Bodicote re-plan comments & DWH response

JOB NO.	DRAWING NO.
7942	BOD.HT.064

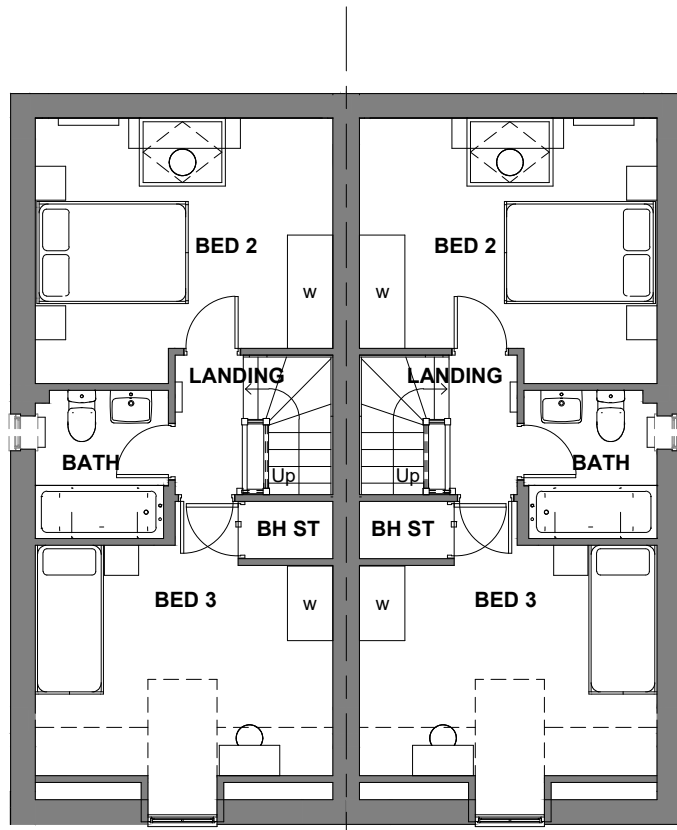
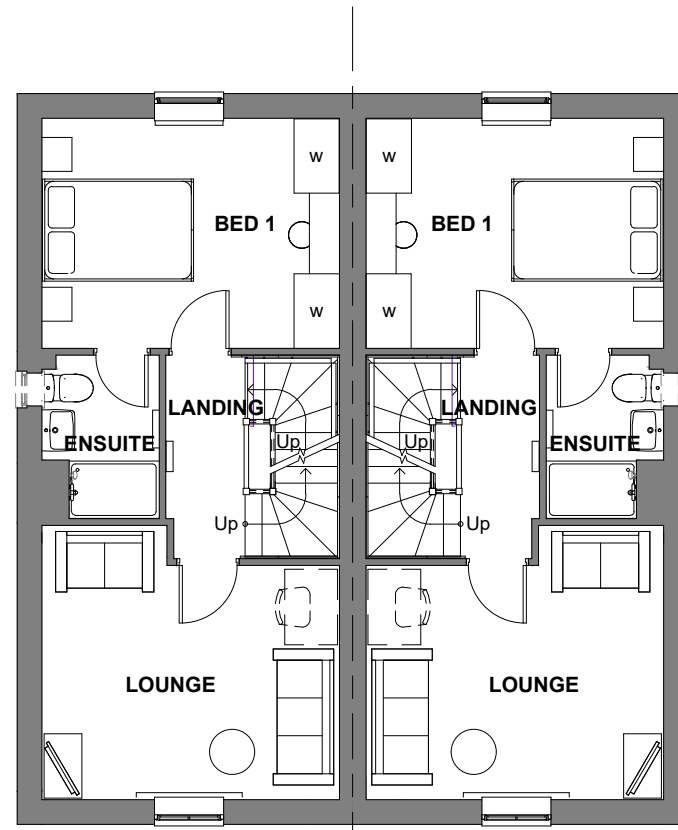
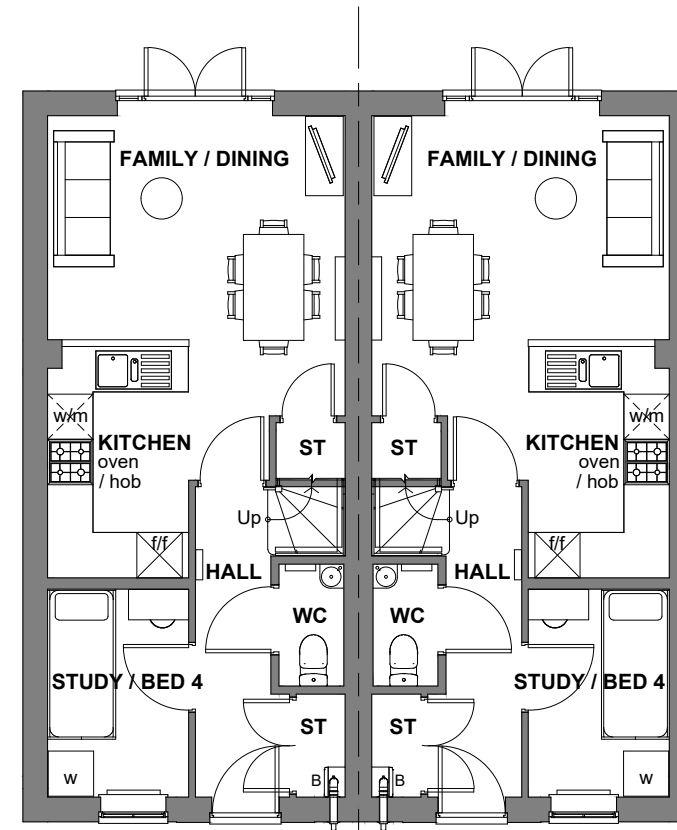
Comments	Response
<p>Strategic Housing Officer in respect of the additional affordable housing provision requires them to meet the NDSS standards, those currently indicated are too small and must be amended accordingly.</p>	<p>All of the affordable house types within the Re-plan area now meet NDSS standard. Please see the updated planning layout and the new Planning House type drawings for SH52 & T50. Drawing number: SH52 = BOD-HT-030-031 Revision A T50 = BOD-HT-066-067 Revision A</p>
<p>Thames Water have advised that the infrastructure does not currently have capacity to take the additional development. I understand that they have tried to contact the applicant but to no avail regarding this.</p>	<p>We will accept the condition. DG has responded to Thames Water also.</p>
<p>The Kingsville has a catslide roof which is not acceptable in design terms and is not locally distinctive. This house type must be replaced with a suitable alternative.</p>	<p>The catslide roof has now been changed on the Kingsville housetype. Please refer to the new house type drawing. Drawing number: BOD.HT.064-065 Revision A</p>
